From: [REDACTED]
Sent: 18 January 2012 11:08
To: Peter Cleveland
Cc: 'Liz Galloway'
Subject: RE: LU/339/11 & LU/338/11/L 13 a Western Road
Attachments: 11047 BOWMAN 13a Western Road 02 Proposed Details.pdf; 11047 BOWMAN 13a Western Road 01.a EXISTING & PROPOSED.pdf

From: Peter Cleveland [mailto:Peter.Cleveland@arun.gov.uk]
Sent: 05 January 2012 10:53
To: Liz Galloway
Subject: LU/339/11 & LU/338/11/L 13 a Western Road

With reference to the above application, the Listed Building Officer has raised some concerns regarding the extension which would need to be addressed prior to any recommendation for approval. I have listed

PROPOSED DETAILS
13a Western Road
Littlehampton
West Sussex

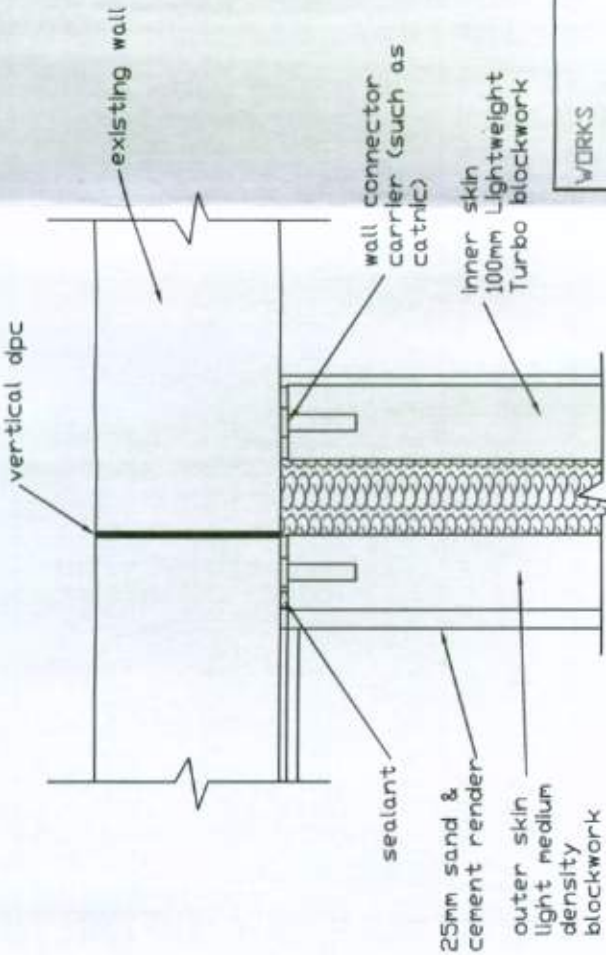
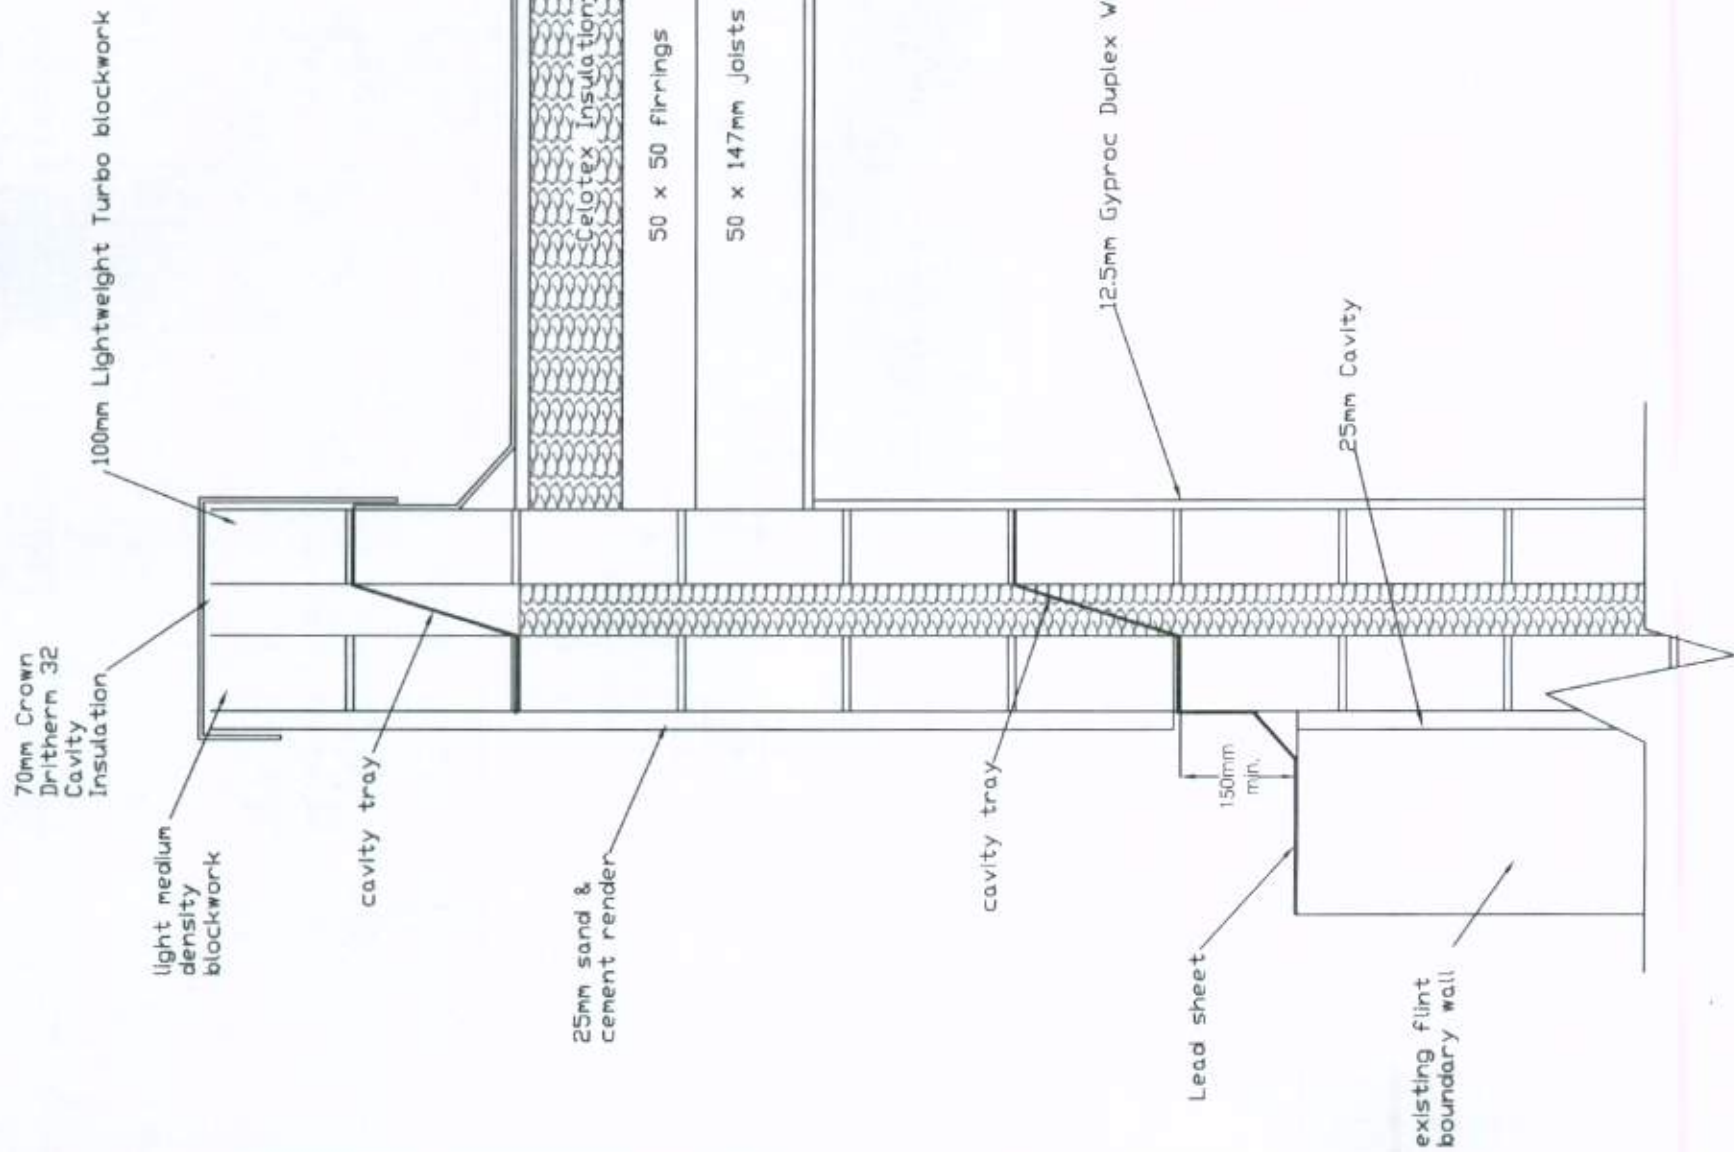
The proposed addition abuts the neighbour's boundary wall but should not harm it in any way. Please provide details of the new structure and a method statement for its implementation to ensure the protection of this wall.

The parapet to the rear requires some form of detail between the elevation and the roof to be submitted.

The fire escape from the new roof level down has been removed.
The railings have been removed.
The roof light has been replaced with a lantern style roof light.
The existing bathroom window has been re-instated. The glazing will be obscured.
Details have been provided for junctions between;

- Existing boundary wall and new wall
- New wall and flat roof
- New external walls and existing external walls
- New flat roof and existing external walls

PROPOSED ROOF PLAN 1:50

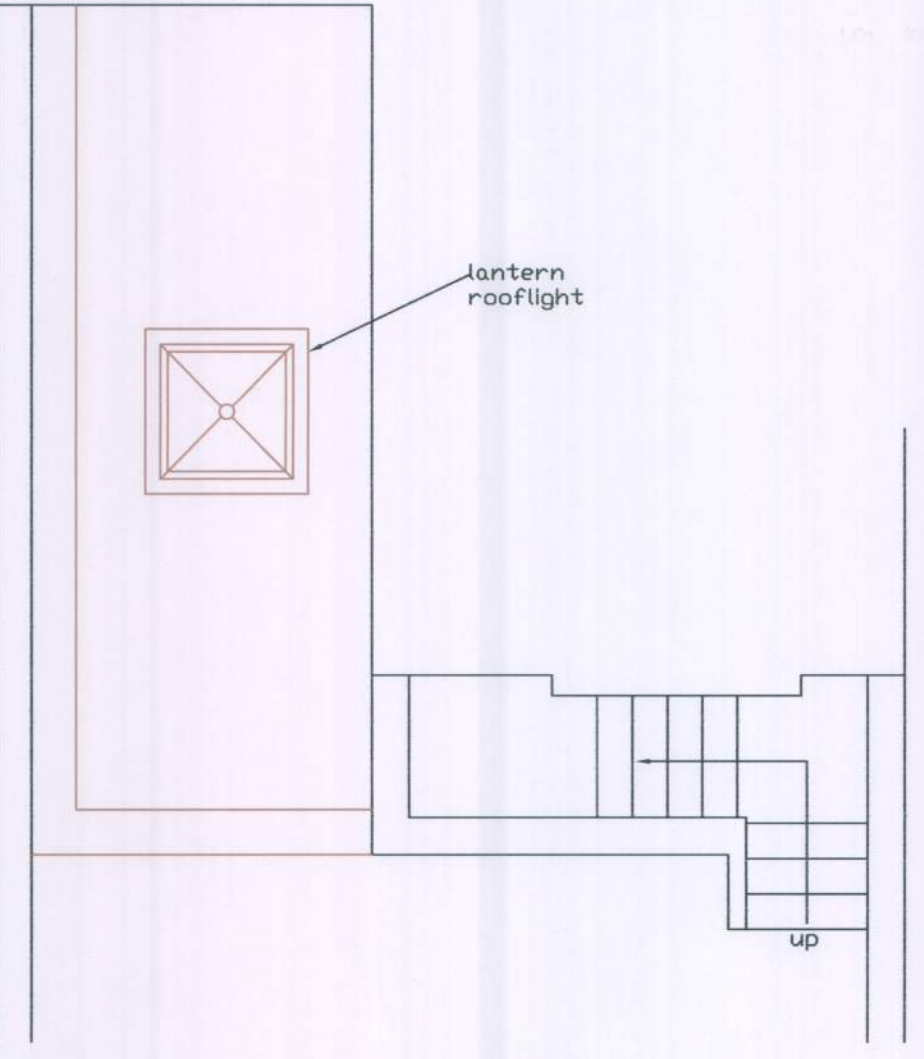
The rooflight should be an acceptable design for a listed building. I would suggest that a lantern is more appropriate and would look more sympathetic internally. Please provide details in due course.

PROPOSED ELEVATION 1:50

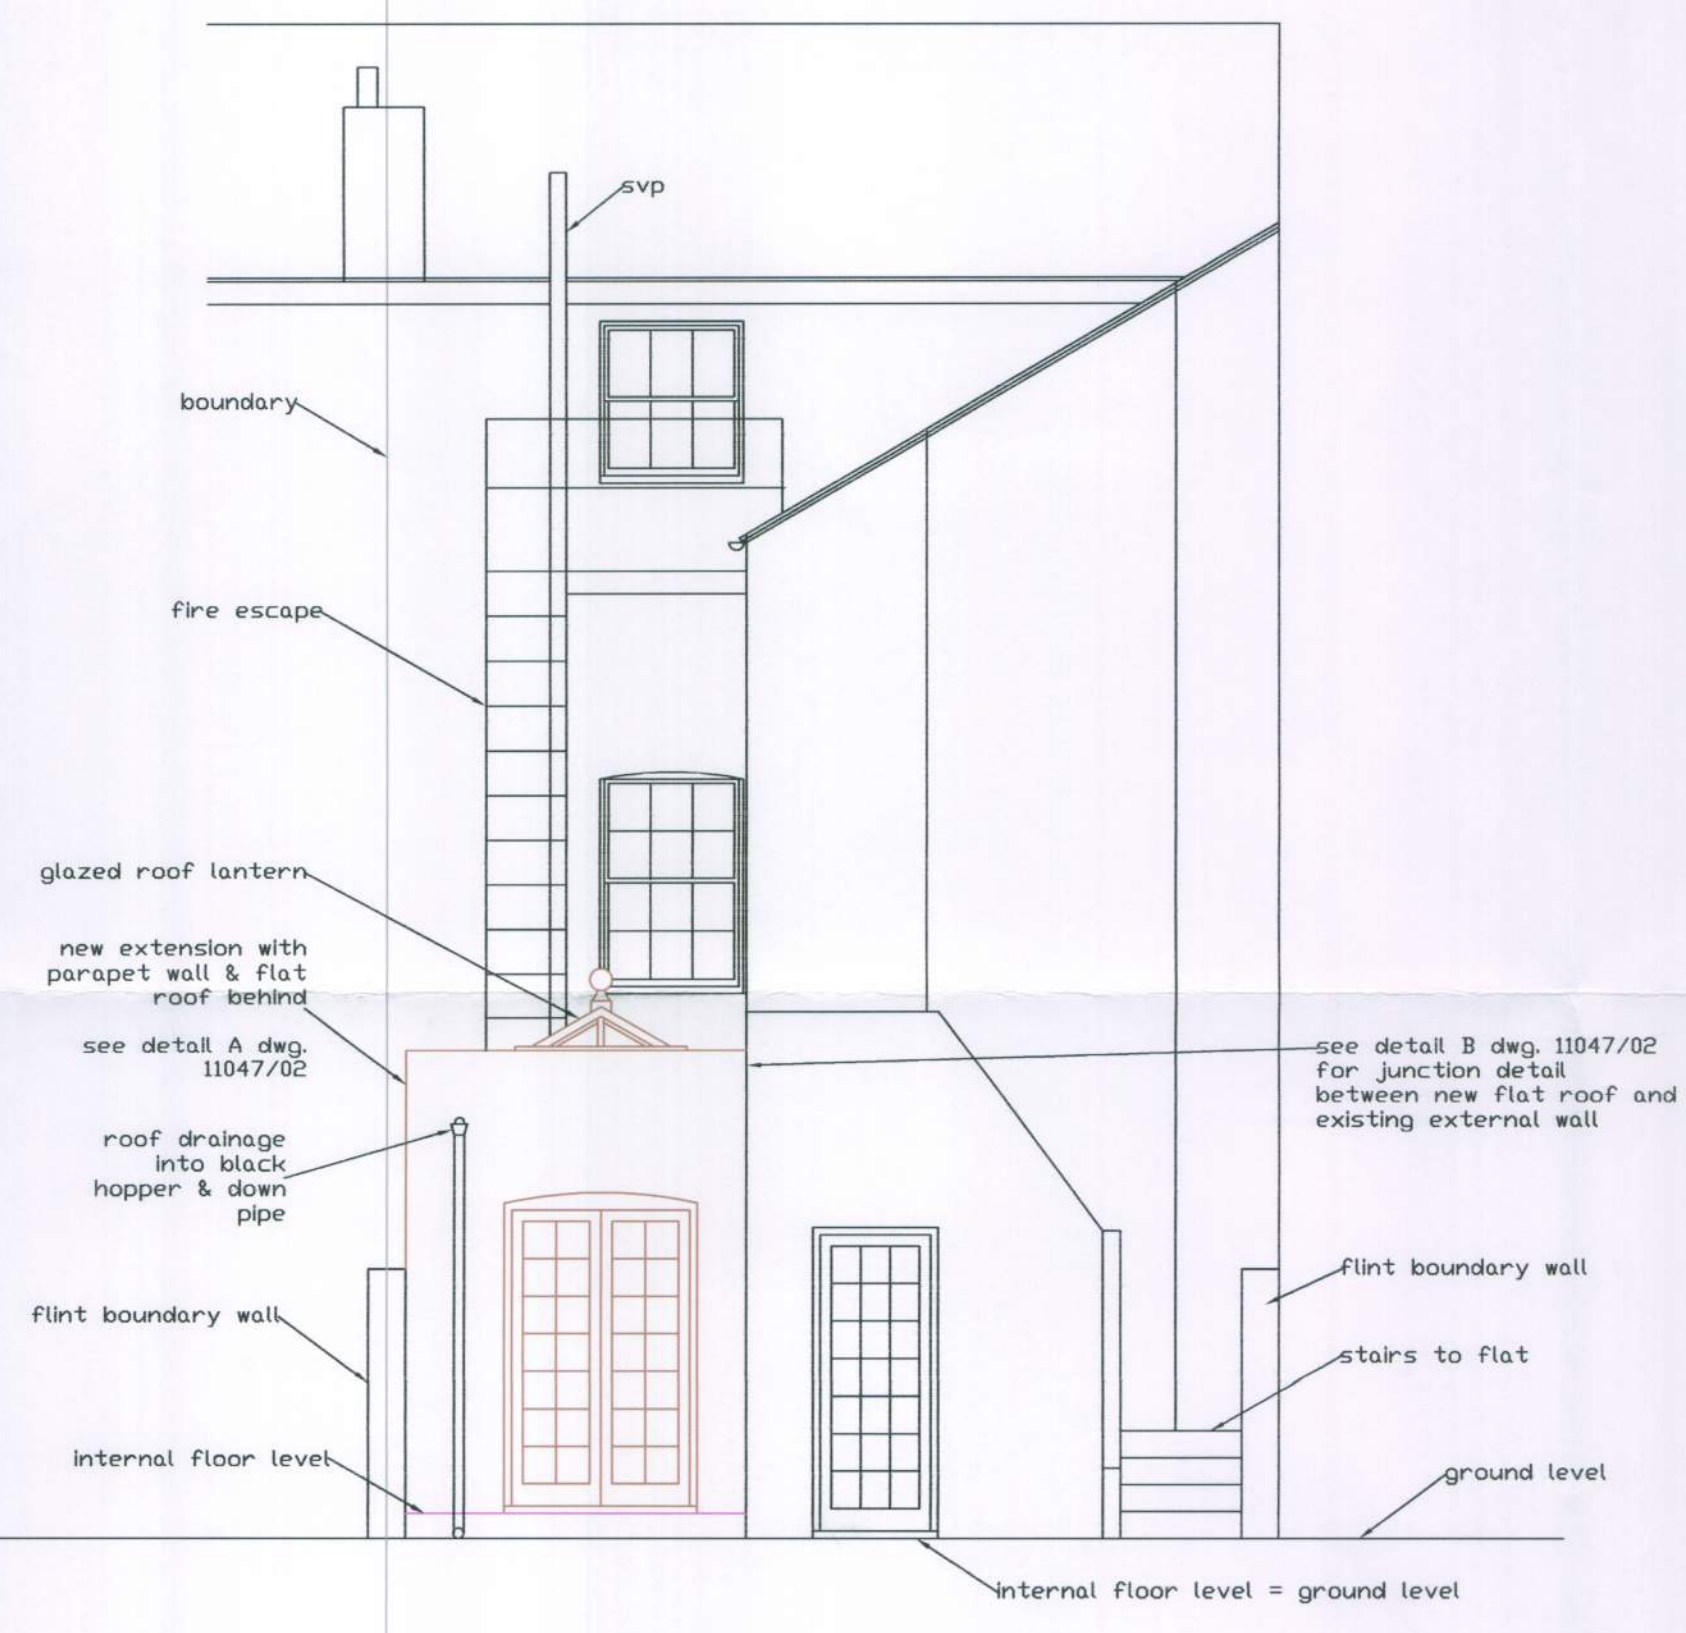
The window between the bathroom and the proposed dining room should be retained to allow for reversibility. The glazing could either be obscured, or the wall blocked on the bathroom side only. The window should remain visible.

The proposed railings to provide the fire escape are also considered to be unsympathetic and would detract from the listed building and appearance of the proposed extension. I have discussed this with our Building Regs department who are more concerned with the internal escape route from upper floors, rather than the external fire escape. There does not appear however to any regulations relating to this site, so this may also be something that you would need to consider.
